Town & Country Planning Act 1990 (as amended)
Town and Country Planning (Development Management Procedure) (England) Order 2015
Approval of details reserved by conditions imposed under FG/95/16/PL relating to condition 6 -
Surface water drainage
Quercus Nursery Littlehampton Road, Ferring,

Arun District Council have decided to **REFUSE** details reserved by condition for the following reasons:

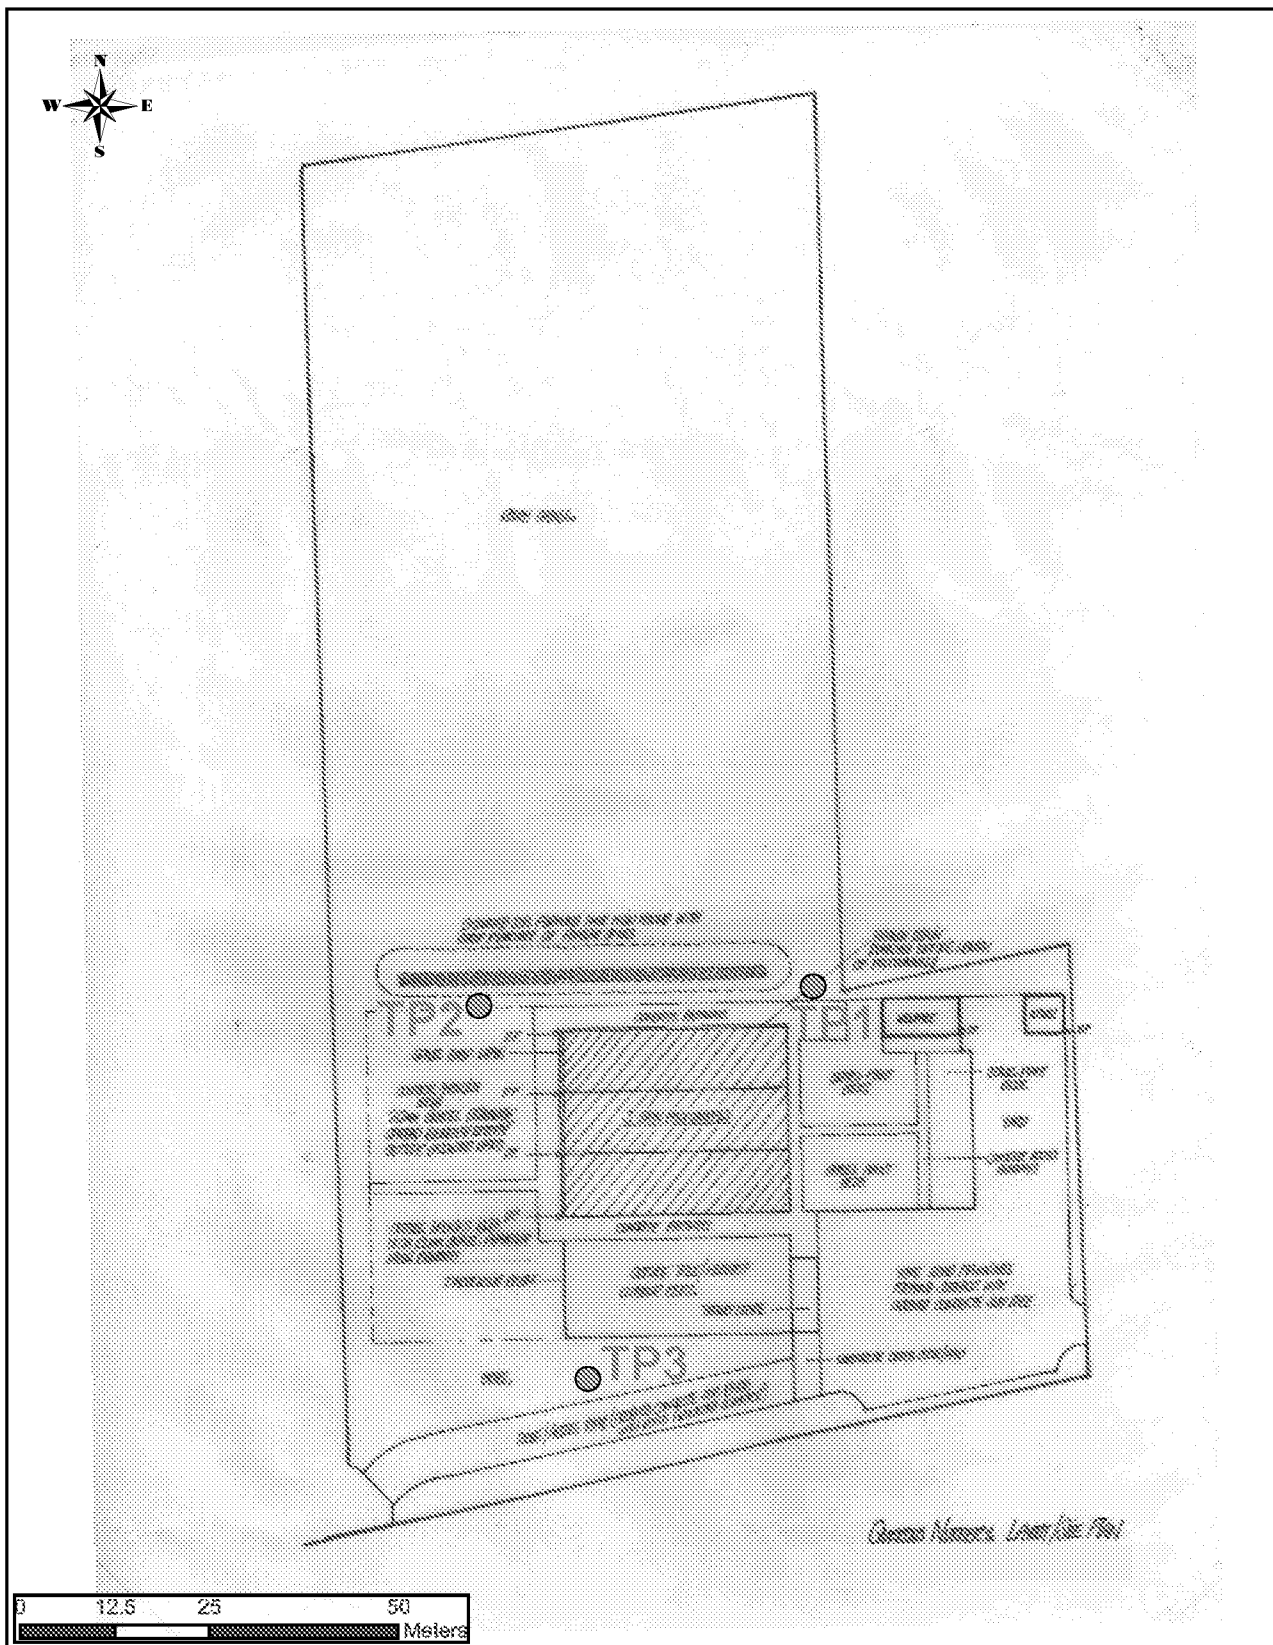
- We require a climate change allowance of 30% to be applied to the calculations for the soakaway trench and principal soakaway as outlined in our conditions imposed on the original application.
- Please provide details of winter groundwater monitoring results.
- The lower infiltration rate between TP3 and TP1 will need to be used, not the average. I.e.

5.99x10⁻⁶ in calculations.

- Please provide details that prove that the 1 in 100 year +30% climate change event can be contained on site.

i.e. supply topographic survey or proposed kerbing/bunding details.
